RE: The Drovers Solar Farm (EN0110013) – Deadline 4 submission

Figure 4-1 Proposed Construction Routing Overview

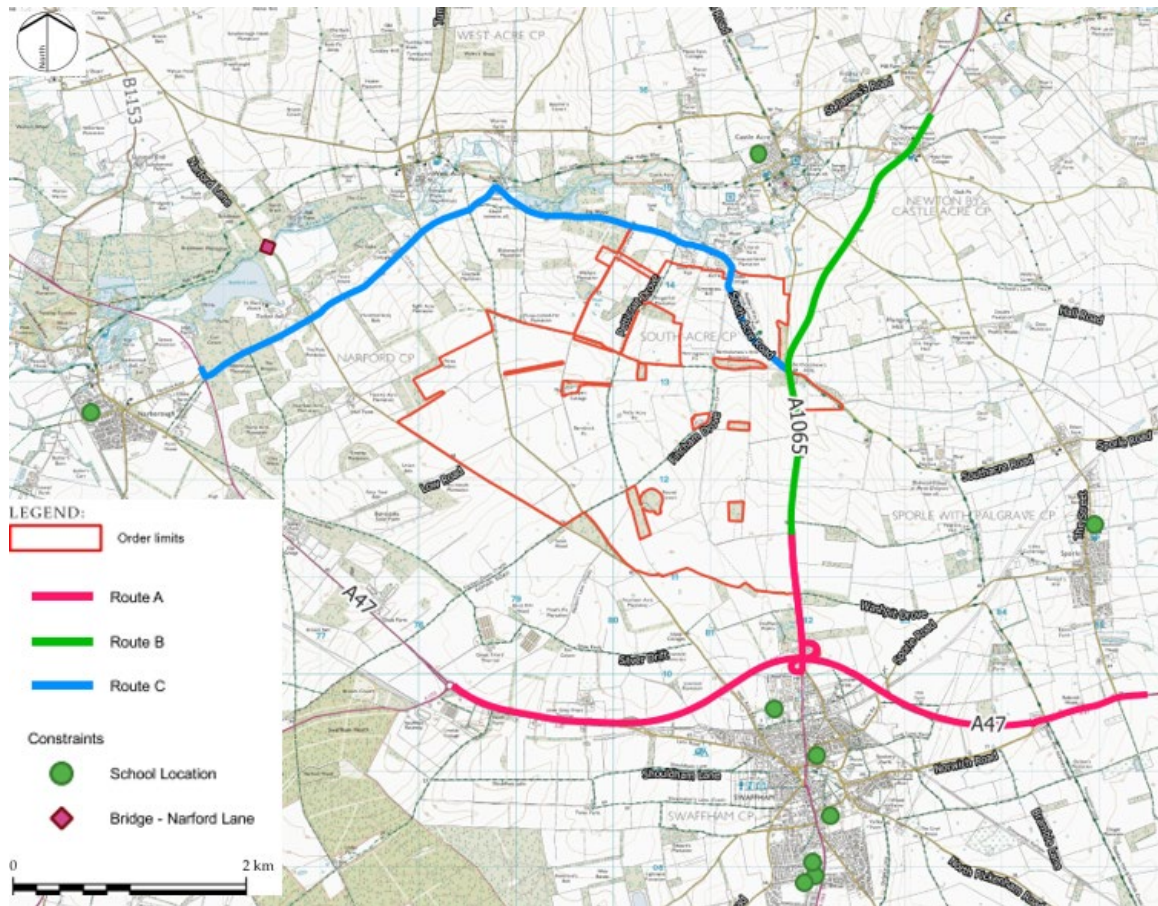
The proposal involves a two-year construction period generating between 600 and 622 daily two-way vehicle movements along the A1065 and A47. Local testimony identifies the A1065 as one of the most dangerous roads in the county, while Norfolk records the highest fatal road collision rate in the UK, yet no localised road safety risk assessment has been undertaken. Perimeter fencing may also funnel wild deer across high-speed stretches of the A1065, increasing collision risks. Deferring key routing, safety and mitigation measures to an outline Construction Traffic Management Plan after consent leaves important highway safety questions unresolved.
